Re: Jindera Solar Farm (SSD-9549) Request for Additional Information

As requested, please see a consolidated response to your request for information (dated 05/05/2020) below.
If you require further clarification, please don't hesitate to contact me by my details below.

## APPENDIX 4: SUBDIVISION PLAN

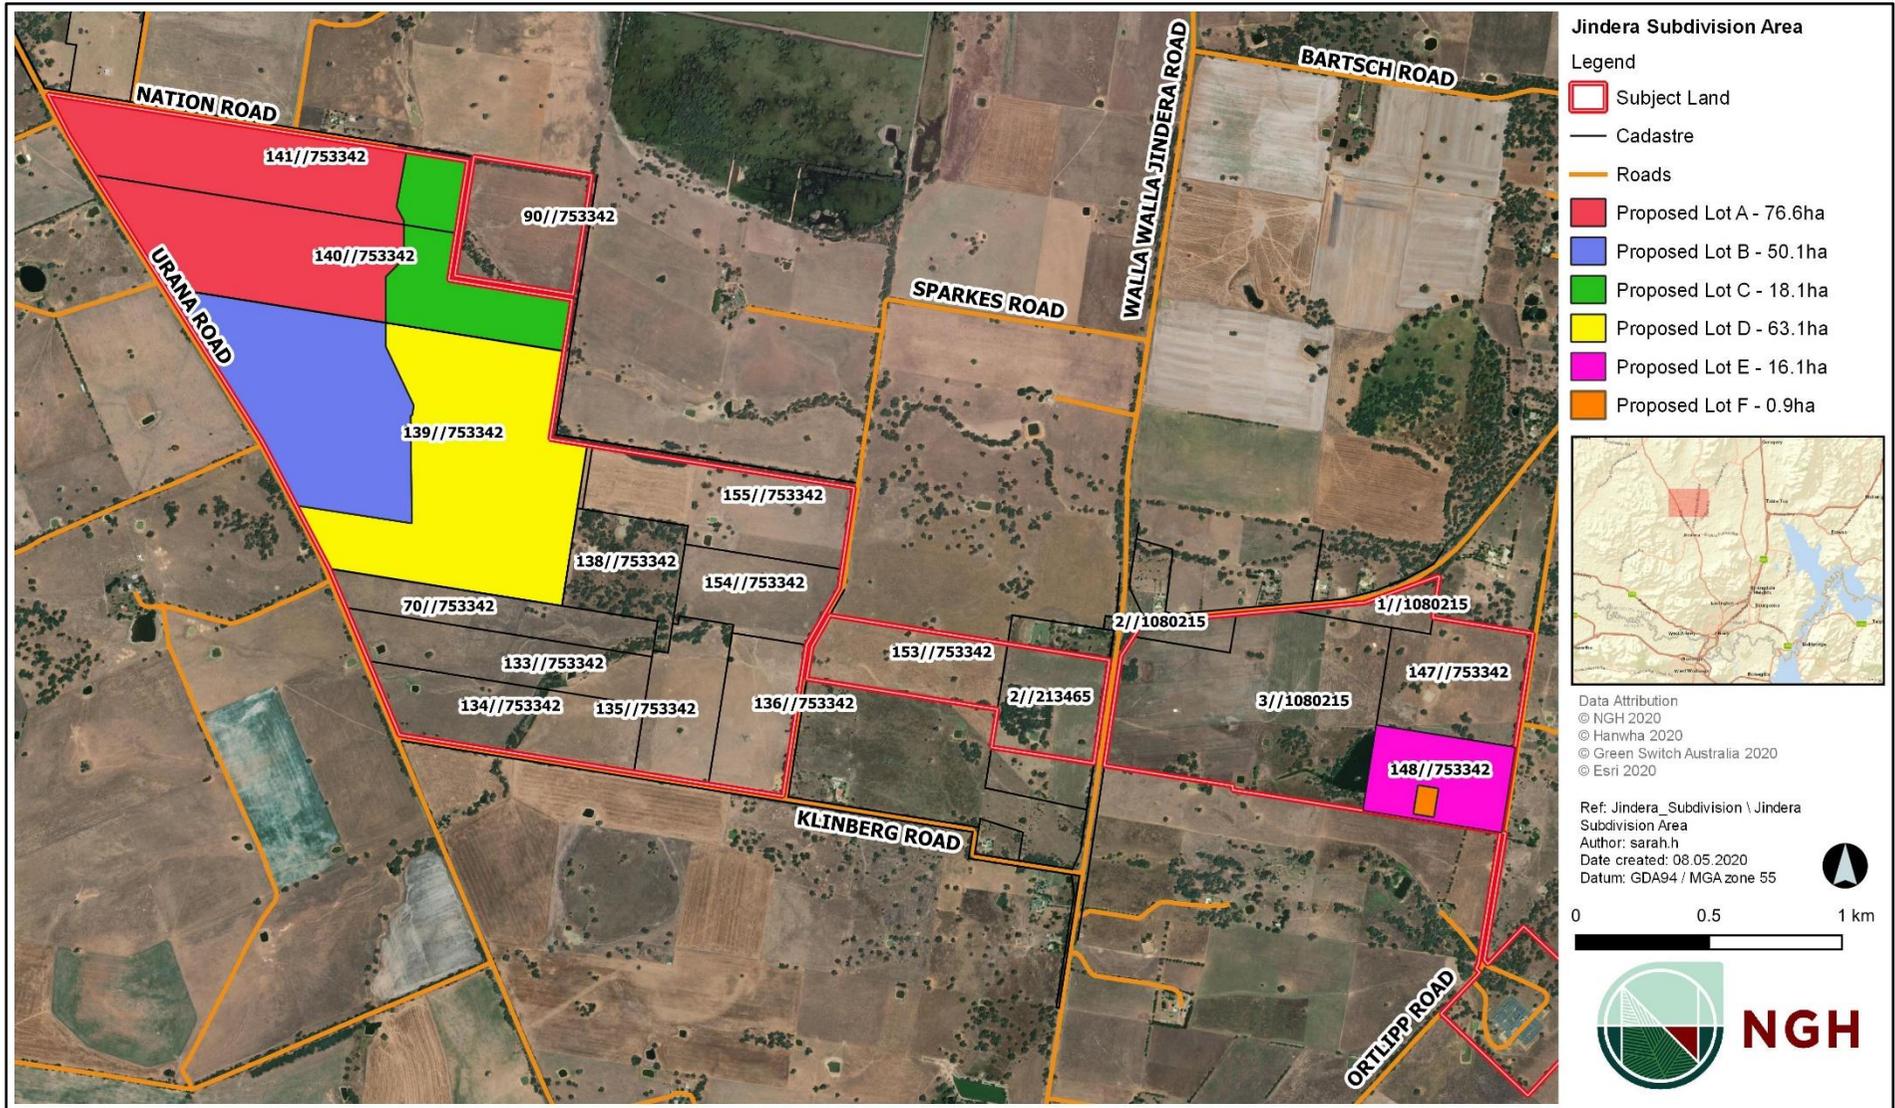
6	Heritage item figures.	<ul style="list-style-type: none"> • Revise figure 13 of the ACHAR to indicate whether items will be avoided, salvaged etc. 	<ul style="list-style-type: none"> • Figure 13 of the ACHAR has been revised. <p>See Appendix A.3 and separate attachment in the portal.</p>
Subdivision			
7	Subdivision requirements.	<ul style="list-style-type: none"> • Confirm that you do not seek to subdivide the land on which the onsite substation is to be located. • Provide a subdivision plan. 	<p>The Proponent is now required to subdivide for the substation.</p> <p>This has been addressed, and the subdivision plan provided, in the separate Amendment Direction (submitted 13/05/2020), which was requested DPIE on the portal on 07/05/2020.</p>
Main project layout			
8	Amendments required to the main project layout.	<ul style="list-style-type: none"> • Ensure panel array legend icon matches the map layer. • Add label for R18 on Glenellen Road. 	<ul style="list-style-type: none"> • The panel array legend item matches the map layer – it is simply a black transparent box. • The label for R18 has been included. <p>See Appendix A.4 and separate attachment in portal.</p>

**Haulage Route Map - Overview**

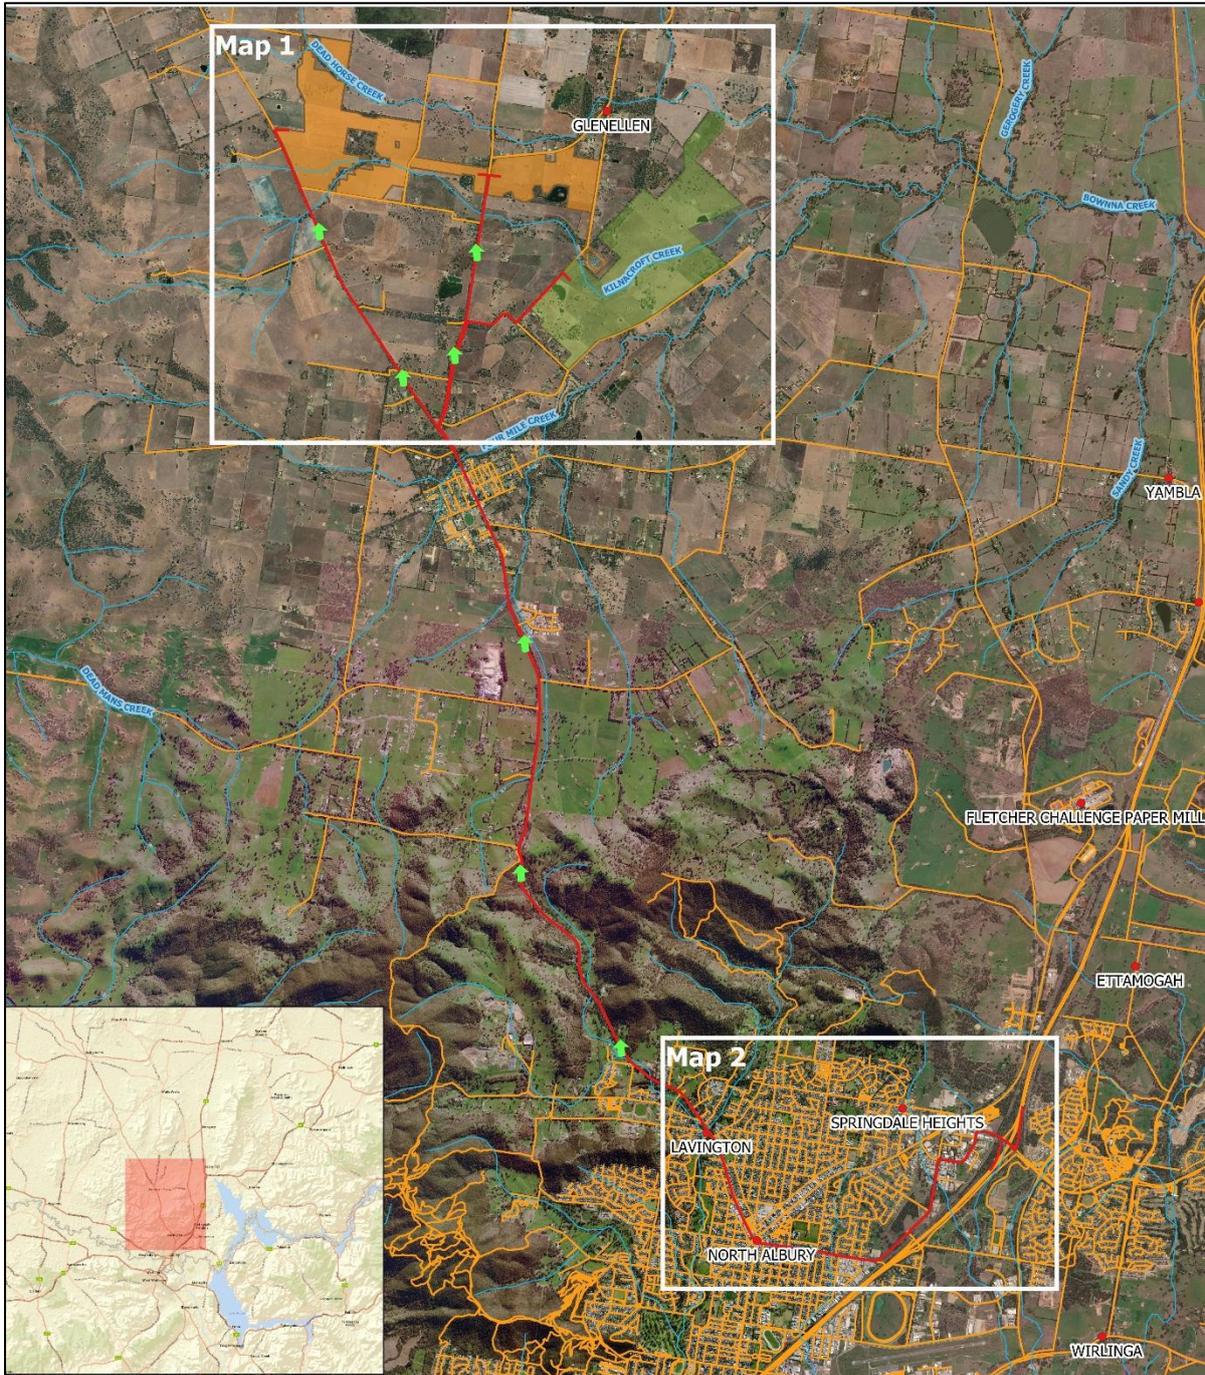
2	Confirm the haulage route from the State Road Network (Hume Highway) and provide a figure which identifies this route.	<p>As a minimum the following details are required:</p> <ul style="list-style-type: none"> Development footprint polygon. Transport route from the Hume Highway. The proposed Glenellen Solar Farm and where the haulage route is common for the two projects. Label all relevant roads, waterways, townships etc. 	<p>The proposed haulage route from the Hume Highway is as follows:</p> <ul style="list-style-type: none"> Thurgoona Road. Catherine Crescent. Dallinger Road. Union Road. Wagga Road. Urana Road. Jindera Walla Walla Road (as required). <p>All traffic will come from the south (northbound) to ensure no heavy vehicle traffic movements on Glenellen Road, or lesser unsealed roads to the north.</p>

<ul style="list-style-type: none"> Mark the road upgrades and site access points. 	<p>The above route was determined from the National Heavy Vehicle Regulator. The route planner is an interactive web-based tool which is continuously updated by (NHVR). The routes have been confirmed by use of the Transport for NSW Restricted Access Mapping tool, published by Transport for NSW. The routes have been modelled for 26m B-double routes and over-sized over-mass routes (OSOM).</p> <p>The Proponent is satisfied that the largest design traffic will be accommodated by the existing geometry of the proposed road network. It is likely that additional permits will be required for any OMOD vehicles entering the site via Urana Road, from its intersection with Hueske Road. Such permits can only, practically be obtained near the time of the proposed movements.</p> <p>The proposed haulage route has been inspected by the proponent including observations of the layout of junctions to ensure the full route is suitable for the proposed traffic, vehicle types and vehicle numbers.</p> <p>The haulage route is shown on the map at Appendix A.1 to this document and is also included as a separate document uploaded to the portal.</p> <ul style="list-style-type: none"> The development footprint of each of the intersections are included. The transport route from the Hume Highway is included. The development footprint of both the Jindera Solar Farm and Glenellen Solar Farm, and where the haulage route is common for both is included. All relevant roads, waterways, towns etc. labelled. All road upgrades and site access points are labelled.
